Please upload the email trail below which is the **ADC Drainage Engineers** consultation response onto Ocella for **BE/21/20/DOC** – Salt Box.

Engineers comments in respect to surface water drainage;

APPLICATION NO: BE/21/20/DOC

Site Address: Land At Salt Box West Of Shripney Road Bognor Regis PO22 9NW

SECTION 1-1
CROSS SECTION THROUGH AT-401
SCALE 1:25
(REFER TO C-7010 FOR LOCATION)

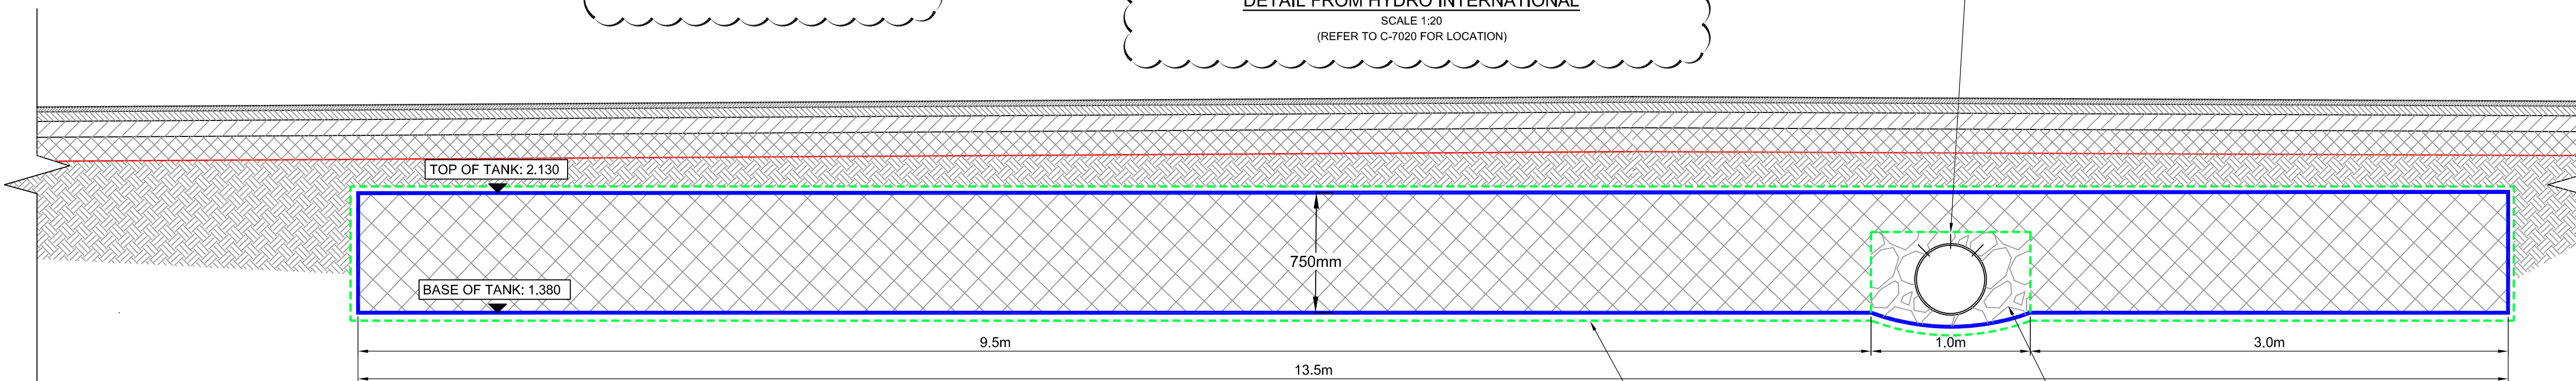
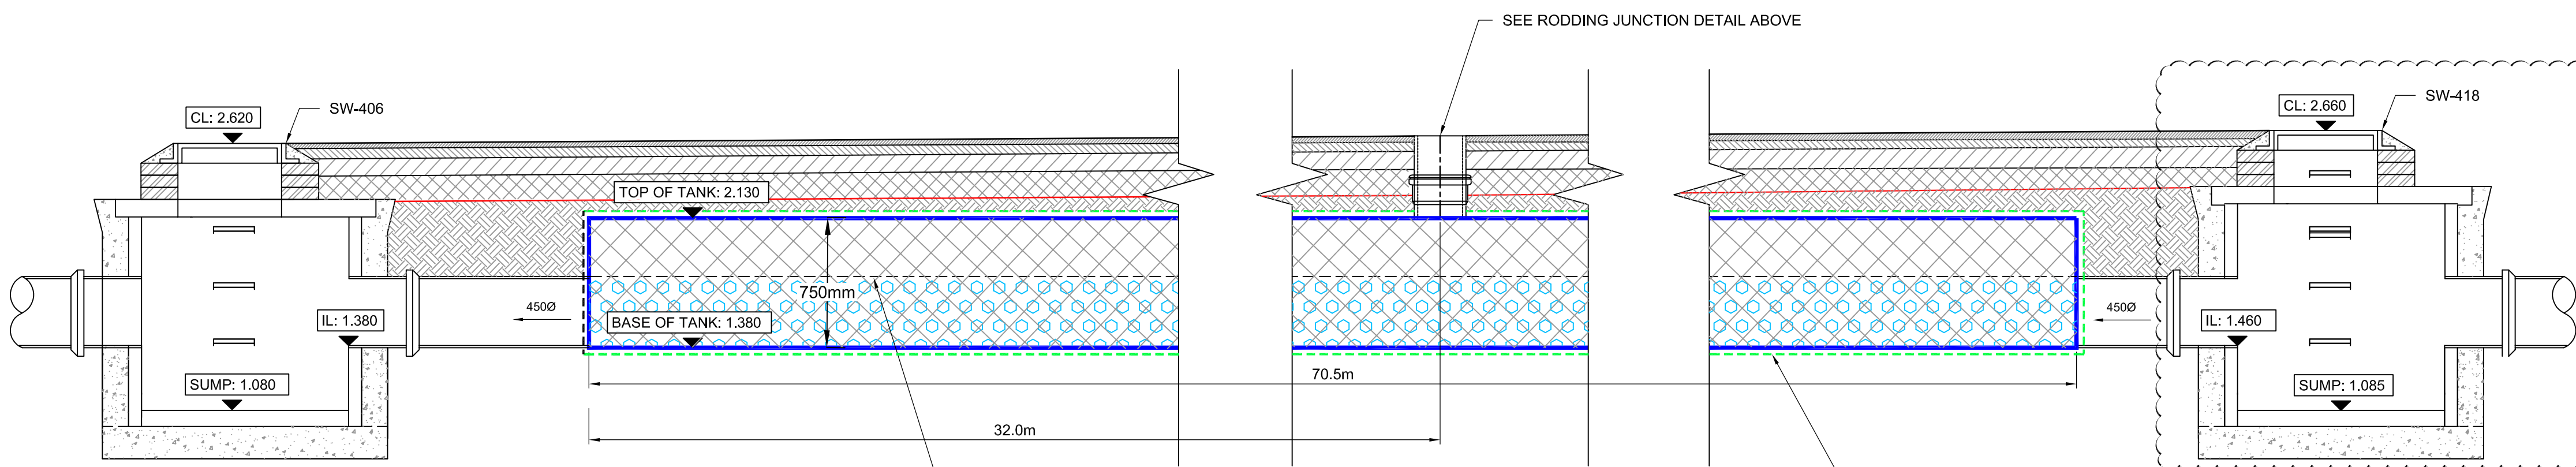
15. Drawing 7010 - SW-405 to tank – specify pipe diameter and a reasonable gradient.
Gradient added ok
16. Drawing 7103 (Phase 2)– Section 2-2 – should this be labelled AT-401?
401 label added. ok

17. Drawings 7103 (Phase 1 & 2) ie. AT-201 and AT-401 – specify granular surround to pipe including thickness. Provide permeable geotextile wrapping to bedding.
Granular material detail note added and permeable textile wrapping note added. Done for AT-401. AT-201 – no drawing supplied? Added to AT-201. Ok but I note that at some point the geotextile surrounding all crated tanks has changed from impermeable to permeable. Please change back to impermeable to prevent groundwater intrusion. Only the geotextile surround to the perforated pipes should be permeable.

18. AT-401 – Provide integral catchpit manhole in crates at connecting junction as opposed to a 300mm vertical pipe.
SDS tanks do not have a tank spec that allows for manholes to be installed within the tank but can provide a rodding access similar to what is shown and they allow for junctions in the pipe. ok but T junction access detail needs to refer to AT-401. Note added. ok
